Our ref: DOC25/1026105-7
Your ref: SSD-66542218

Whitehaven Solar Farm – response to request for further information

Thank you for your request via the NSW Planning Portal dated 25 November 2025 to the Conservation Programs, Heritage and Regulation Group (CPHR) of the NSW Department of Climate Change, Energy, the Environment and Water (NSW DCCEE) inviting comments on the response to the request for further information (RFI, dated 25 November 2025) for the Whitehaven Solar Farm.

Plate 2: Example of Vegetation Condition and Vegetation Integrity Score Ranges Before and After Partial Loss

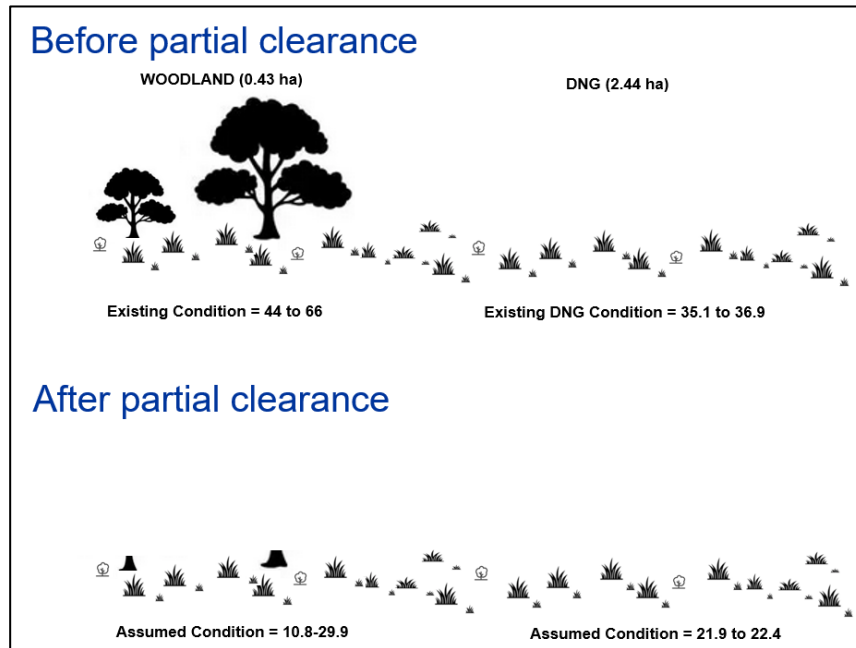
The RFI document does not provide an ecological justification for the proposed future VI scores in Management Zone 2, just that the scores are 'conservatively less'.

To address these issues, we recommend the conditions capture:

- the future VI score for each vegetation zone
- the need to complete BAM plots within 3 months of clearing and construction of the infrastructure to determine the VI score following disturbance
- the number of BAM plots required in each vegetation zone
- the requirement that BAM plots will need to be completed for the life of the project to confirm that the future VI score is being maintained
- consequences of the future VI score dropping below that listed in the conditions.

In addition, the BMP must state what management activities will occur in Management Zone 2 to assist in the maintenance of the future VI score, which should include the preparation of a Trigger Action Response Plan (TARP).
